Savage Development Group  
2454 Waynoka Road  
Colorado Springs, CO 80915

### Letter of Intent

I would like to use the Property located at 2405 Waynoka Road as a fenced storage lot for All American Disposal. Only empty Roll Off containers and equipment will be stored in the fenced area. We understand that we need a transfer station variance to store full containers and we are not looking for that variance nor will we store full containers on the lot. With the approval of this fenced storage area the weekend and night dumpers of illegal trash should be cut down drastically and help keep the area clean of waste generated from the public not All American Disposal. I would like to develop the lot in future years to a commercial building, so the fenced storage lot is a temporary use of the land as All American Disposal is actively searching for larger facilities.

SITE DEVELOPMENT PLAN
CIMARRON-NORTHWEST INDUSTRIAL FILING NO. 4
 A REPLAT OF A PORTION OF LOT 1, BLOCK 2 CIMARRON-NORTHEAST INDUSTRIAL NORTHWEST
 LOCATED IN SECTION 6, TOWNSHIP 14 SOUTH, RANGE 65 WEST OF THE 6TH P.M.
 EL PASO COUNTY, COLORADO
 LOT 1 SCHLAUFMAN SUBDIVISION NO. 1., PLAT 12717

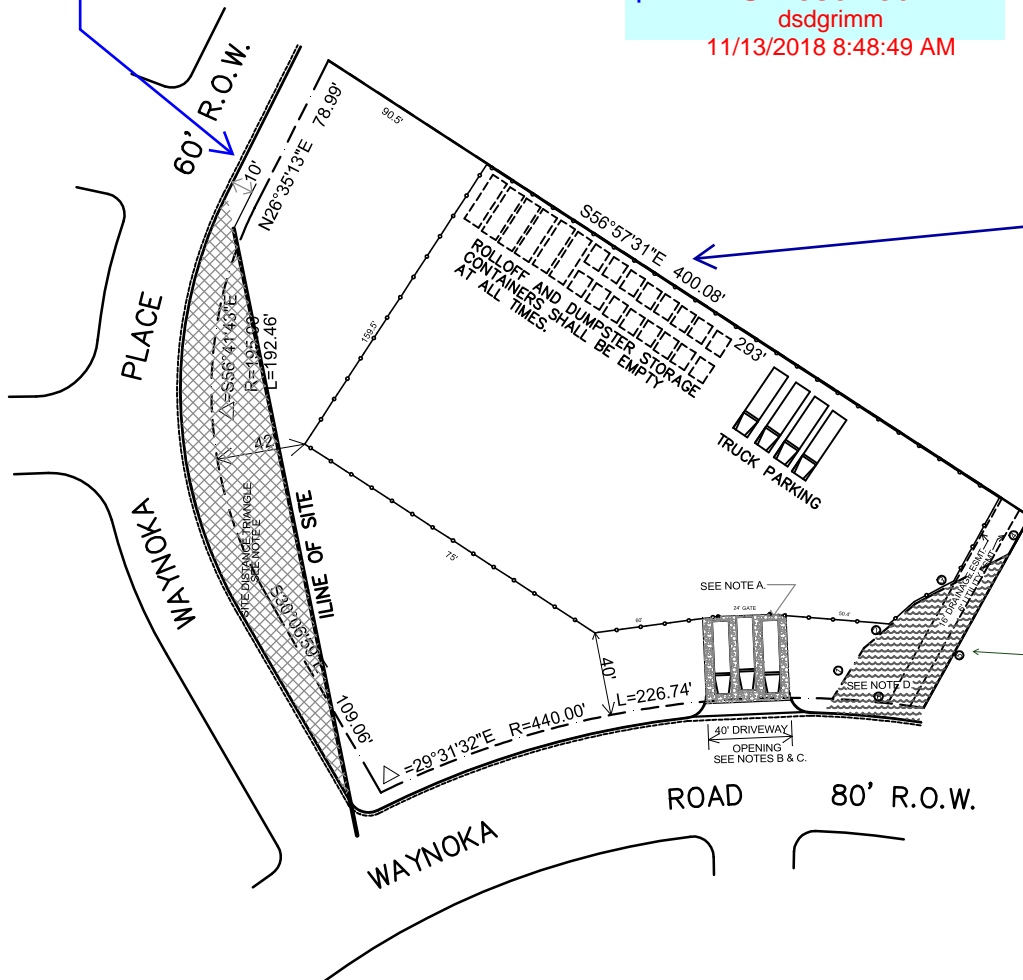
It appears this property is currently being used for additional parking by the adjacent property to the south. Discuss in detail in the letter of intent. Are you intending to continue the overflow parking use on the property or will it be removed? If you plan to keep the overflow parking then the site plan must show this area and must be paved.
